**DEVELOPMENT APPLICATION
ASSESSMENT REPORT:**

***Wild Mouse Tenancy Fitout – Luna Park,
Milsons Point***

DA 8240

July 2017

WEST ELEVATION :EXISTING DA FACADE

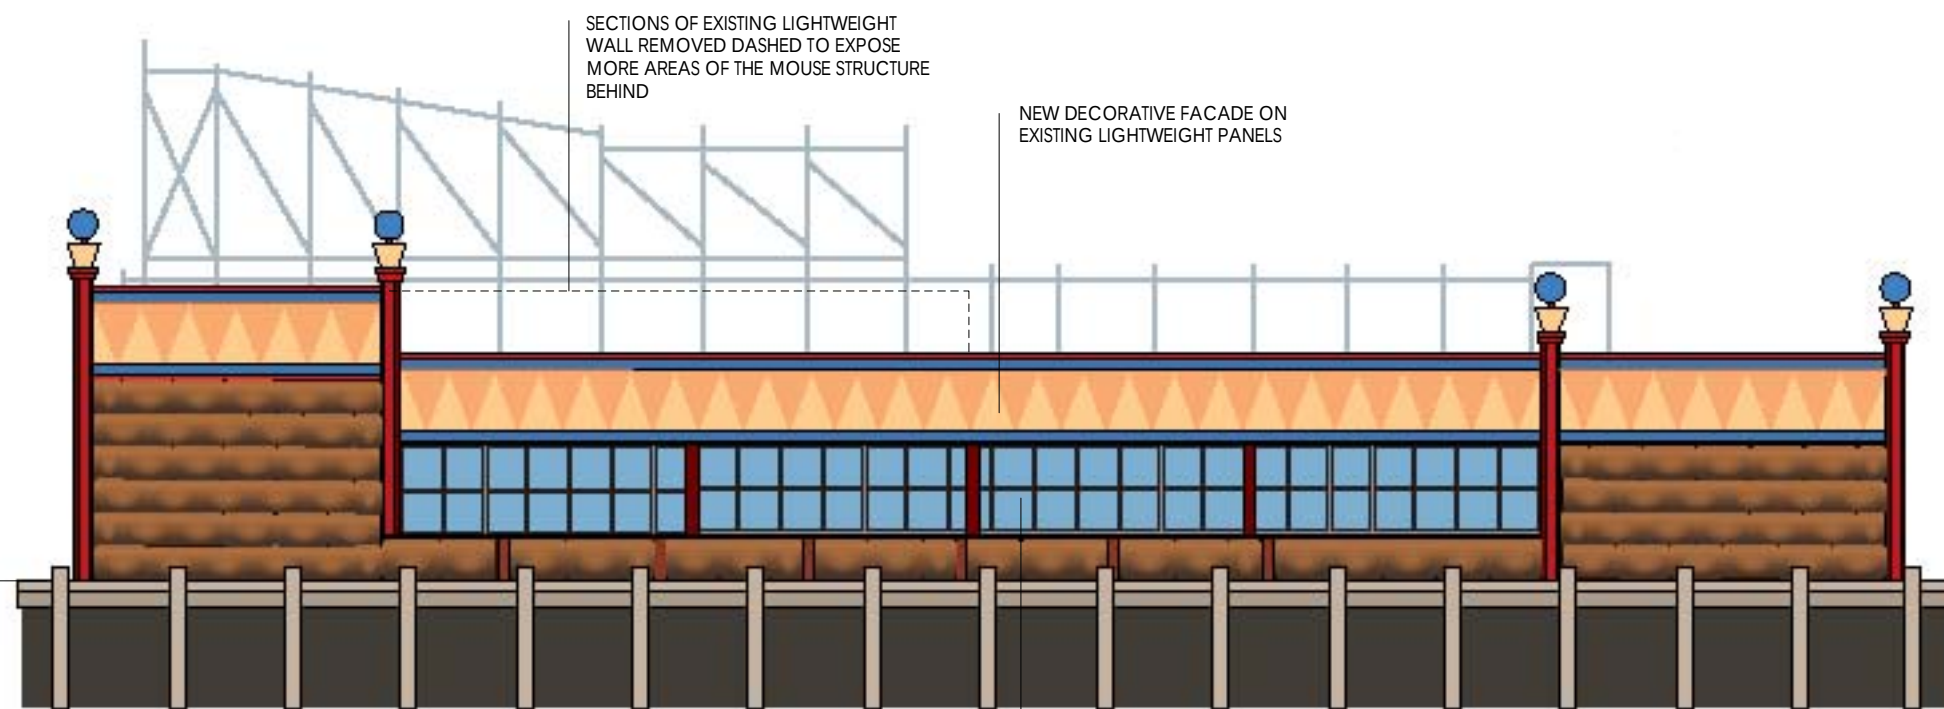
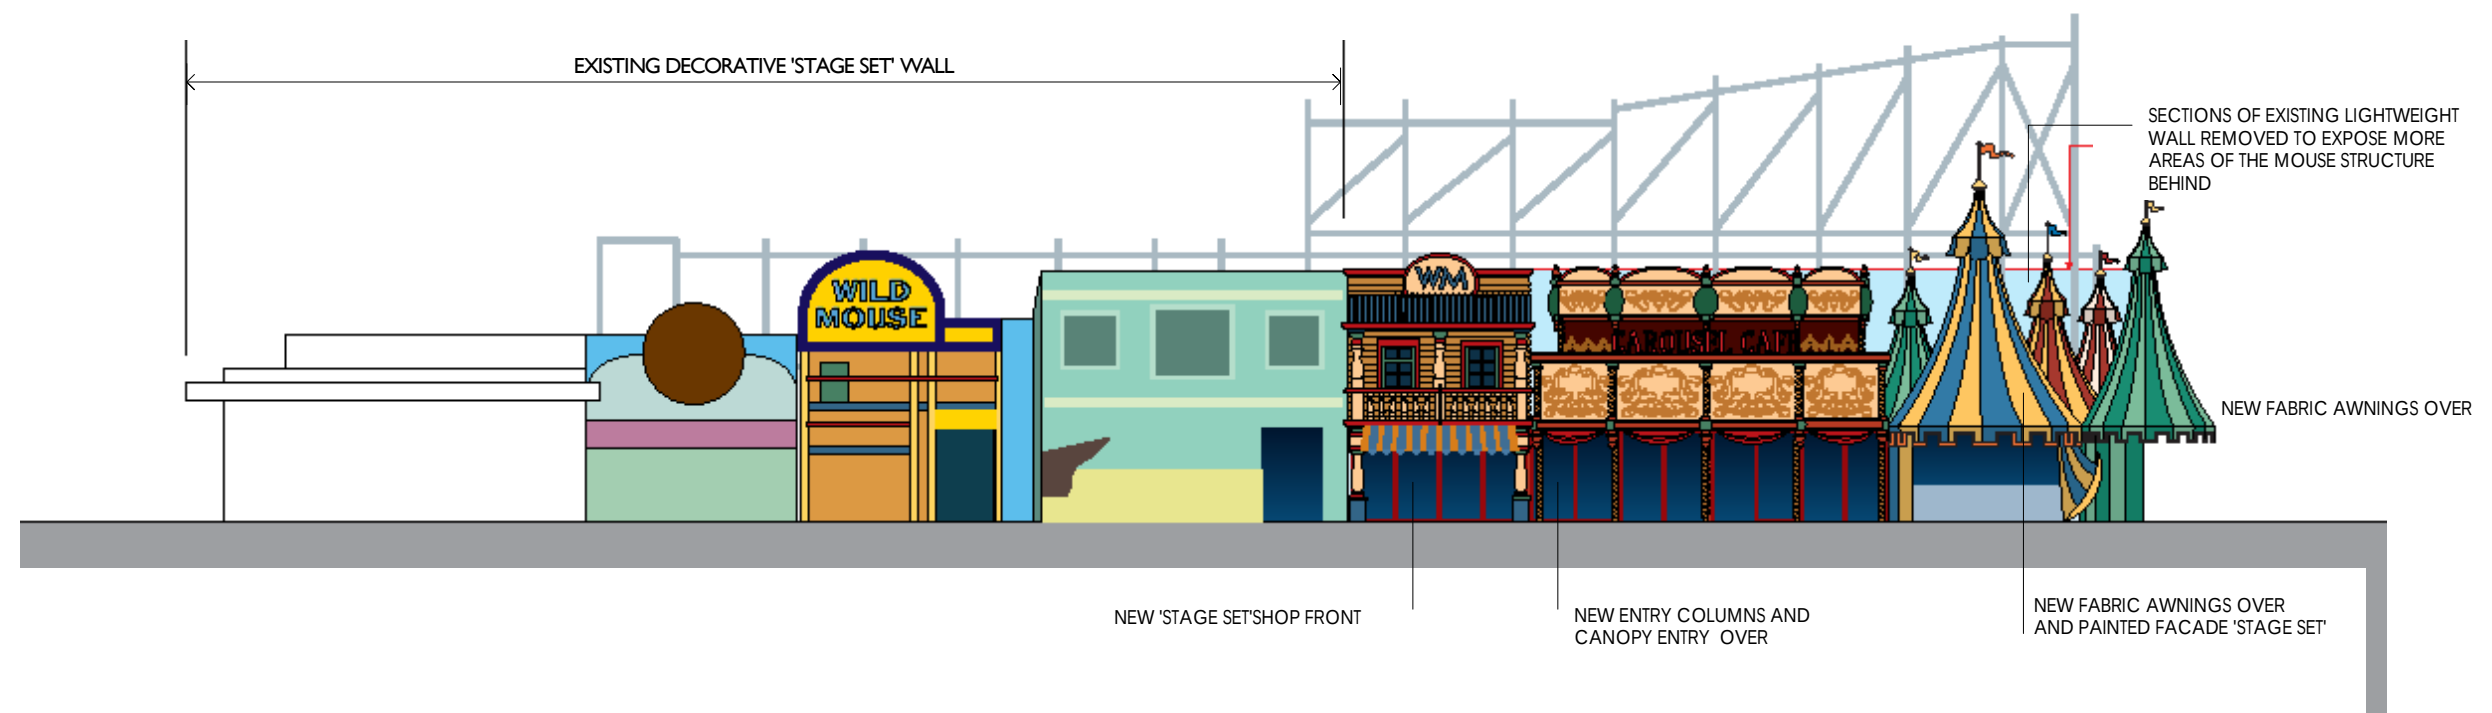
The Lavender Bay Precinct Committee raised the following issues relating to the proposed design of the western façade:

- whether the changes encroach on the boardwalk more than the present western façade
- whether the proposed colour scheme of the western façade breaches the original concept for the Wild Mouse building.

The Lavender Bay Precinct Committee raised the issue of whether removing part of the wall on the western façade would release more noise from the Wild Mouse ride (see **Figure 10**).

The architectural plans do not indicate an encroachment into the boardwalk any more than the current façade and will further open up the western façade by removing some lightweight walls and replacing the current concrete blades with louvres as shown in **Figure 10**.

The blue colour scheme currently used on the western façade is not original and does not date from a significant period in the history of the site (**Figure 9**). The 'stylised yellow cheese' façade referred to in the Lavender Bay Precinct Committee's submission is not included in Luna Park's Statement of Significance.

The Department considers the changes proposed to the western façade facing Sydney Harbour is more consistent with the character of Luna Park than the existing blue façade with grey and red triangles.

The Applicant advises the removal of part of the existing lightweight rooftop wall will have negligible implications on the Wild Mouse ride noise levels as the wall is decorative in nature and provides little acoustic absorption. The Department agrees the lightweight wall is a decorative feature. The removal of the wall would not give rise to additional noise impacts given the majority of the Wild Mouse ride already sits above the wall and the wall itself currently only extends partially across the western façade which faces over Lavender Bay.

ELEVATION EAST : TO MIDWAY

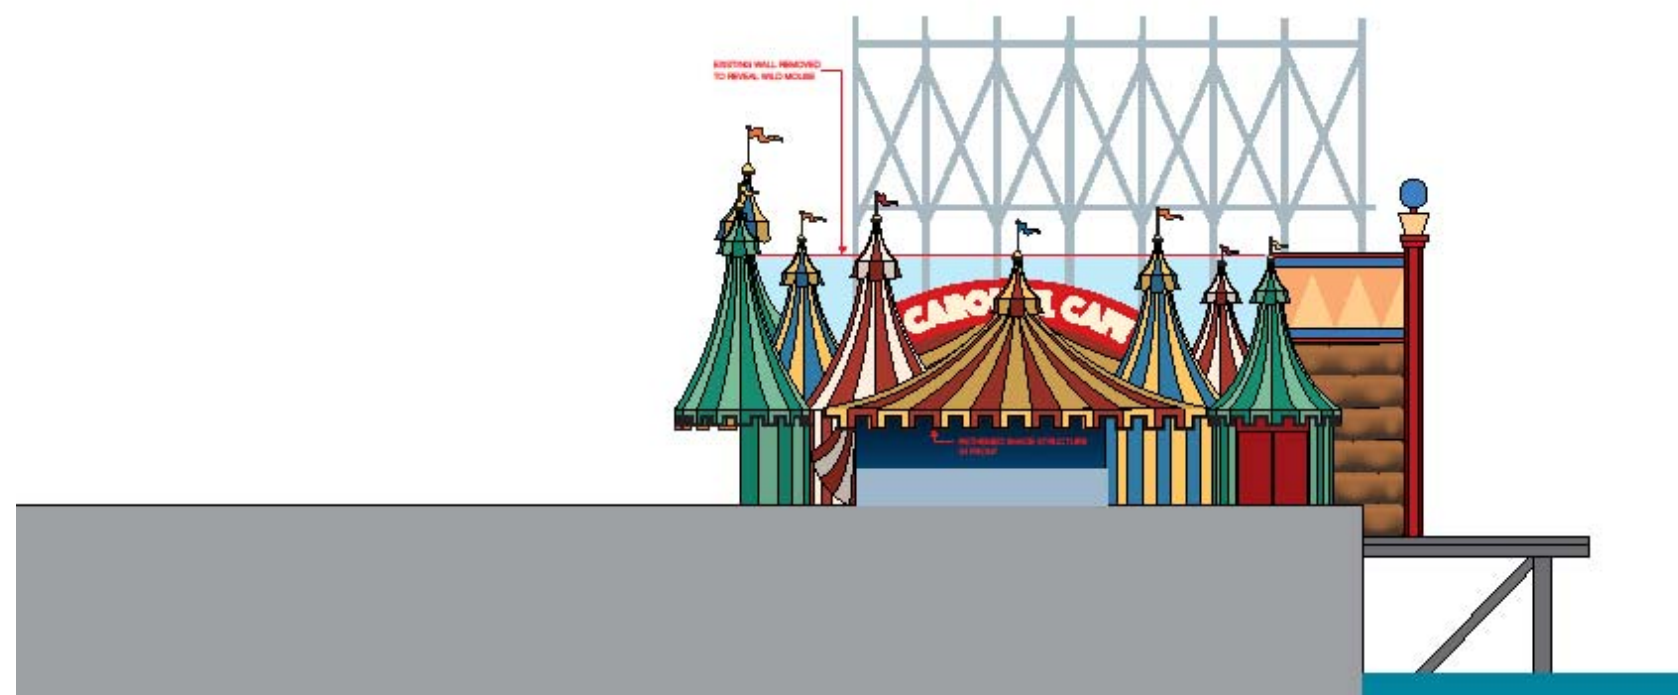
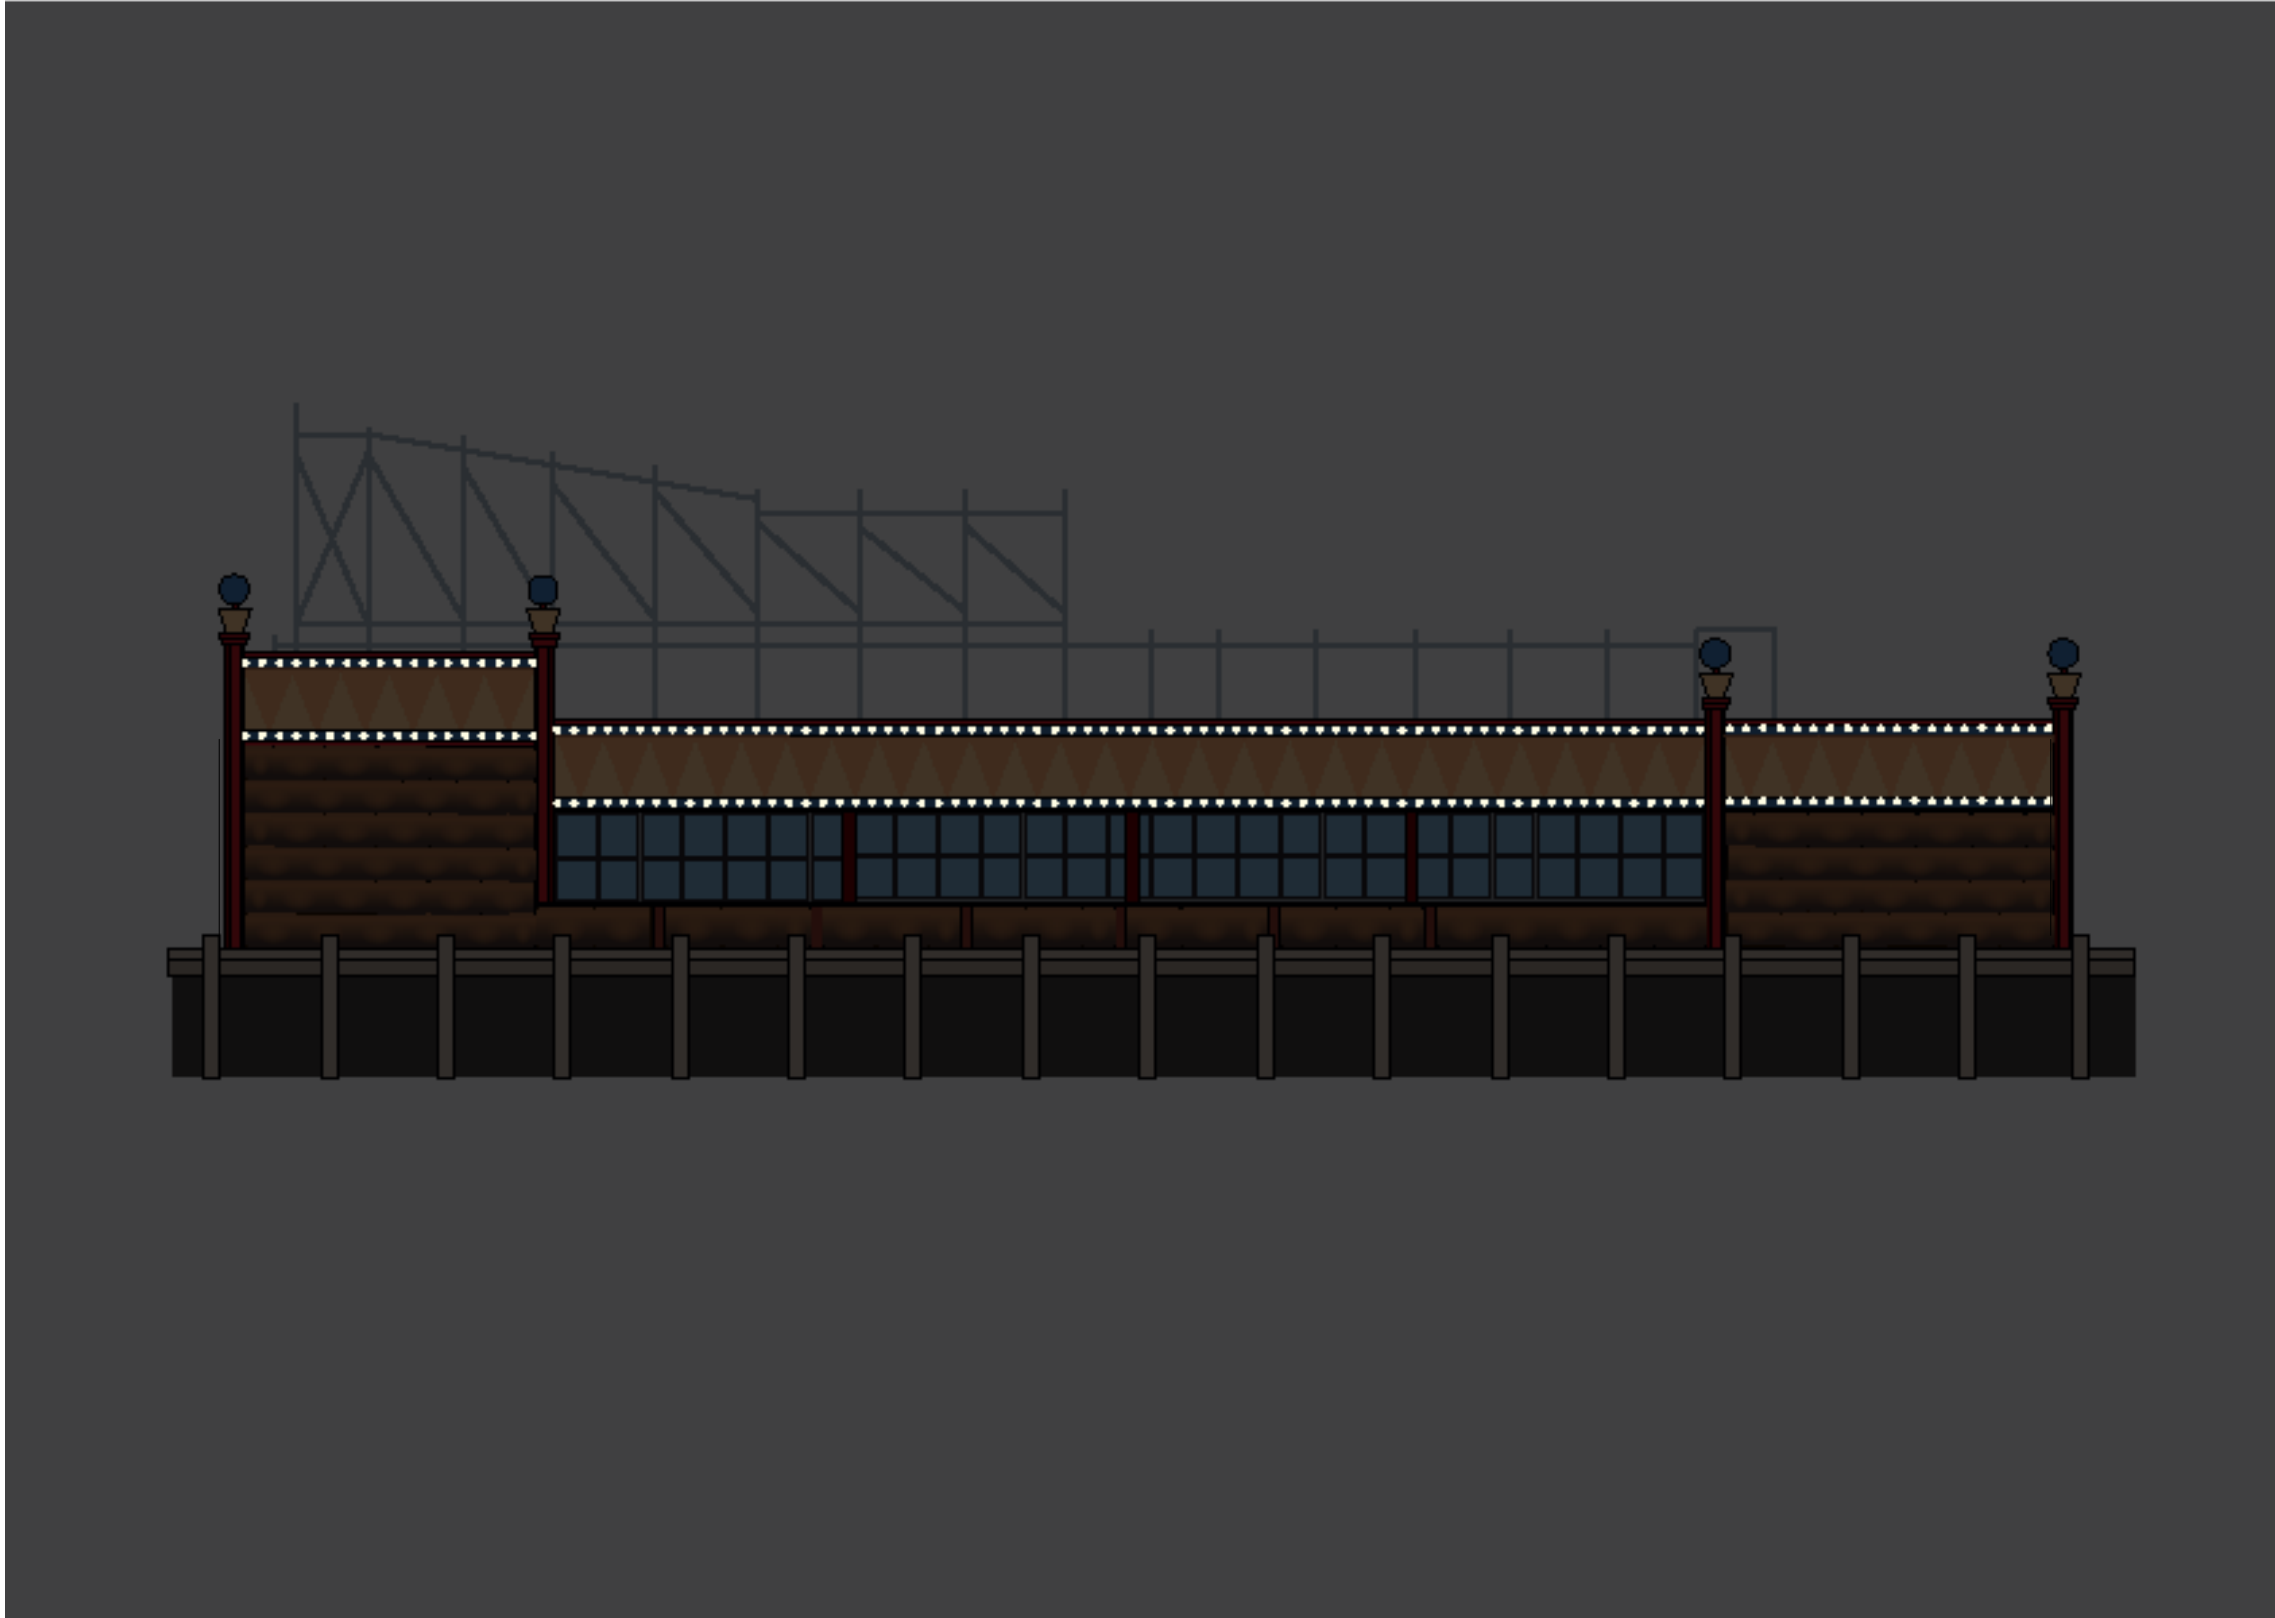
The design details, materials, colours and finishes on the eastern façade facing the Midway would be consistent and compatible with the architectural character of other structures along the Midway (see **Figure 8**). The new appearance of the northern façade facing Coney Island would be consistent with the character of Coney Island and the Crystal Palace with its red, blue and yellow colour and design scheme.

LIGHTING ELEVATION WEST

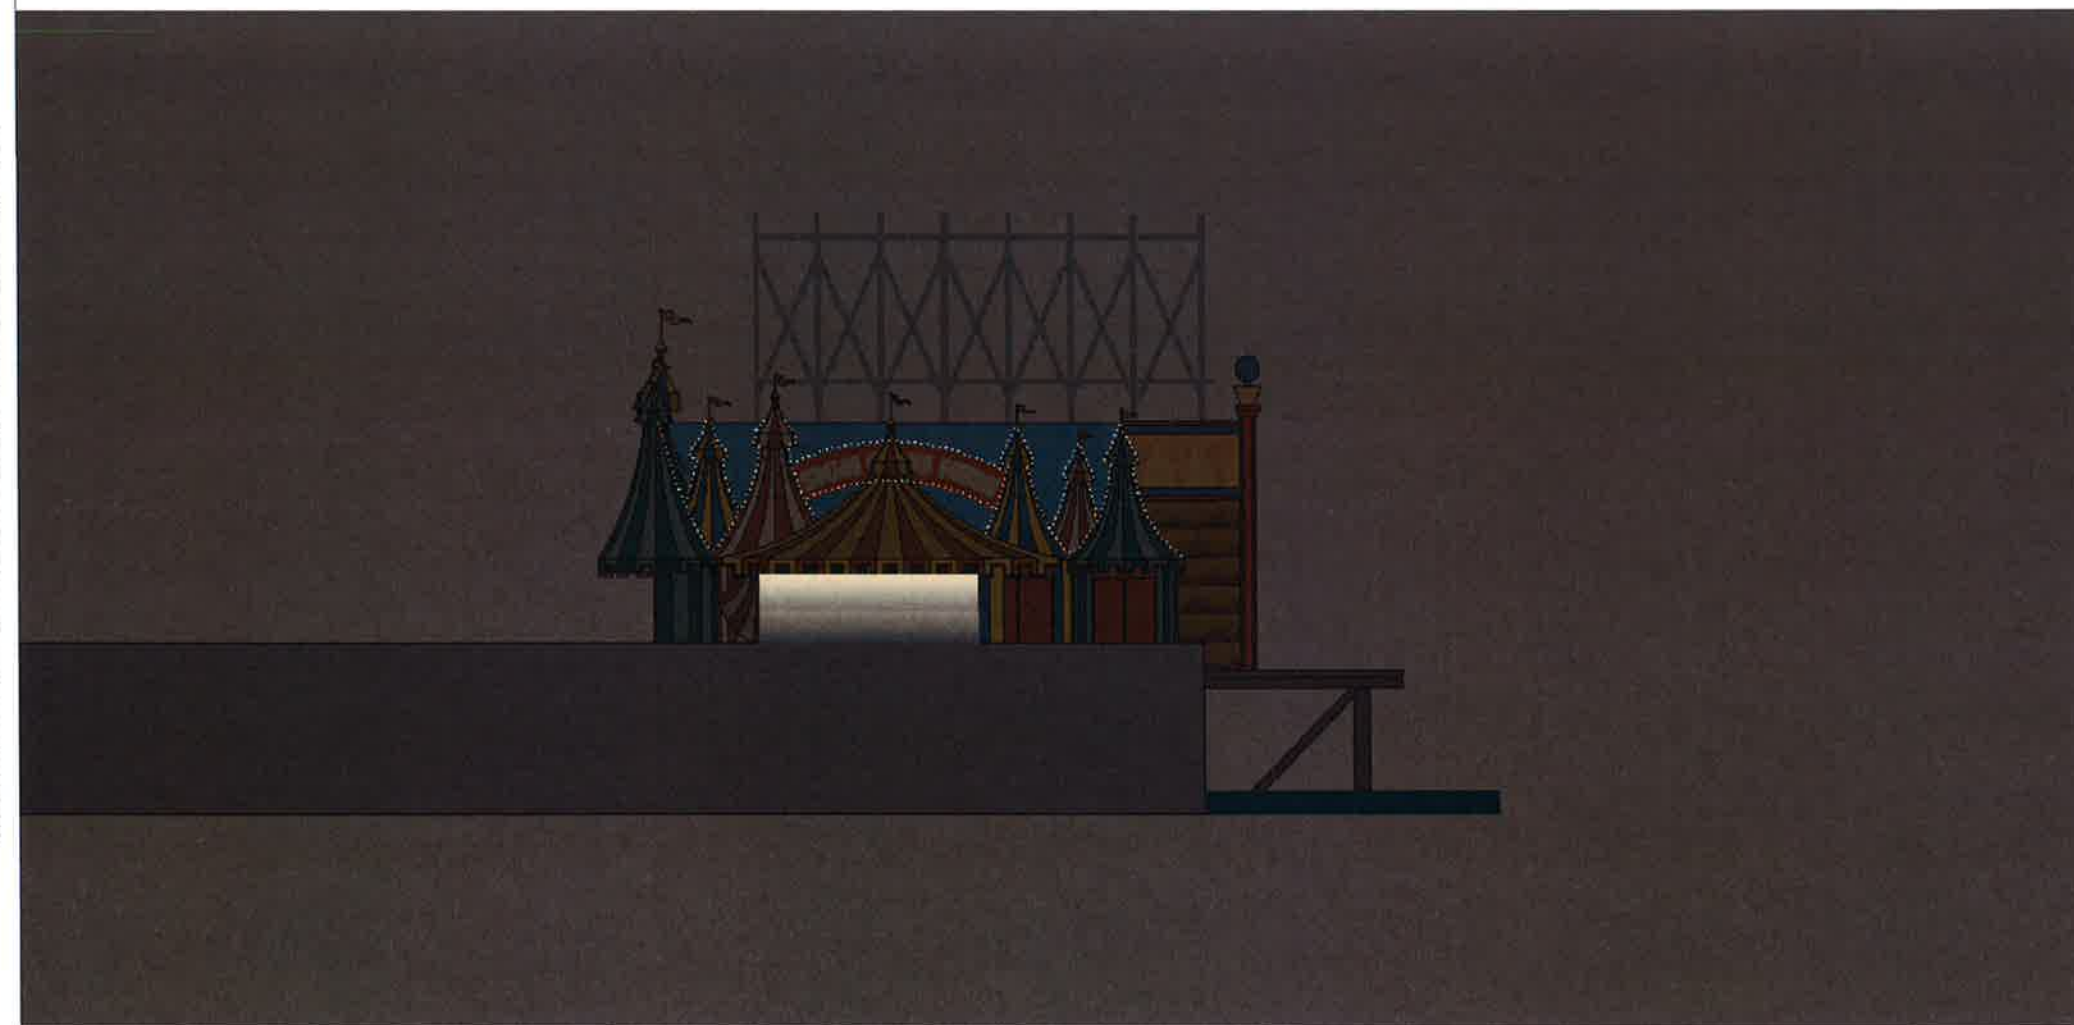
Small Light Emitting Diode (LED) lightbulbs are proposed to be located along the edges of all facades of the Wild Mouse Building as identified in **Figures 13, 14 and 15**. The existing lighting is minimal on the western façade, which faces Lavender Bay and the Sydney Opera House. The northern and eastern facades have small LED lighting around the edges of the decorative murals.

While the Wild Mouse sits on the foreshore of Sydney Harbour, the Department considers the lighting on the Wild Mouse Building would not create additional amenity impacts to key sites, such as Sydney Opera House and the Sydney Harbour Bridge. This is because of the significant amount of lighting already used at Luna Park and the minimal lighting proposed for the western façade of the Wild Mouse Building which faces these key sites (**Figures 14 and 15**).

However, as a safeguard and for completeness, the Department recommends a new Lighting Strategy is prepared for the renovated Wild Mouse Building which is consistent with the existing Lighting Strategy for Luna Park and which would outline mitigation measures to control the effects of the lighting on the surrounding area.
